CITY OF ALBUQUERQUE

June 28, 2018

**Re: ABQ North Storage
Erosion and Sediment Control Plan
Engineer's Stamp Date 6-19-18 (F15E052E)**

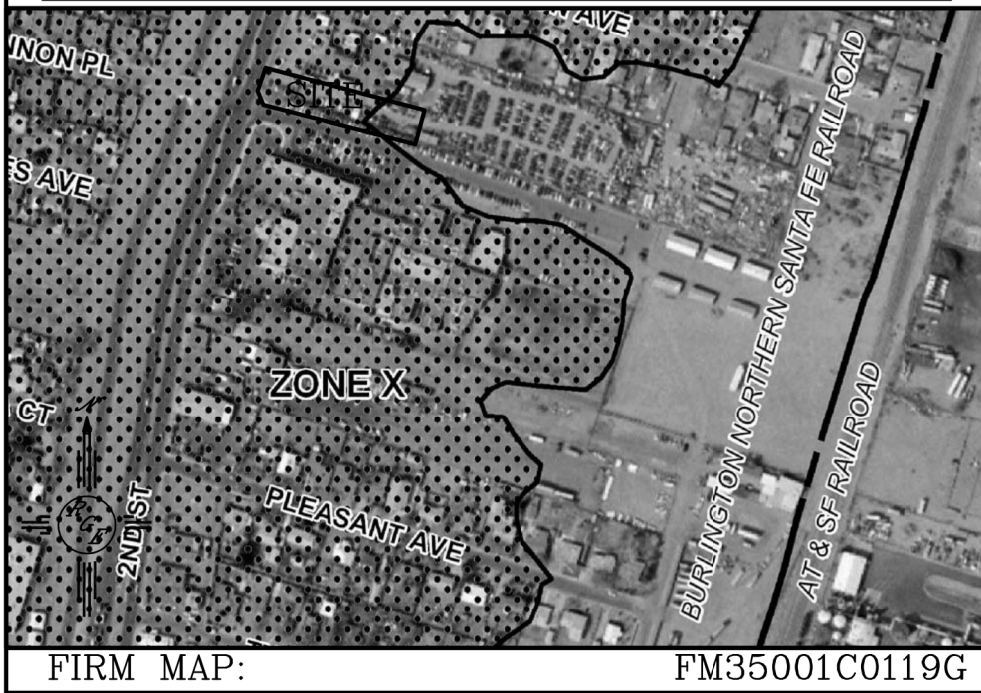
1. The fence shown on the plans:
 - a. Has been removed from the existing entrance to the east boundary
 - b. Was not present at the time of my site visit on 6-28-18 along the eastern edge of the project.
 - c. Is to be removed and replaced along the western edge of the project.
 - d. Photos are attached to the e-mail accompanying this letter.
2. Provide a sediment BMP along the south, east and west edges of the site.
3. The silt fence shown around the pond in the western area of the site is proposed across impervious surfaces in some locations. Provide a sediment BMP that will create a seal on an impervious surface, where necessary.
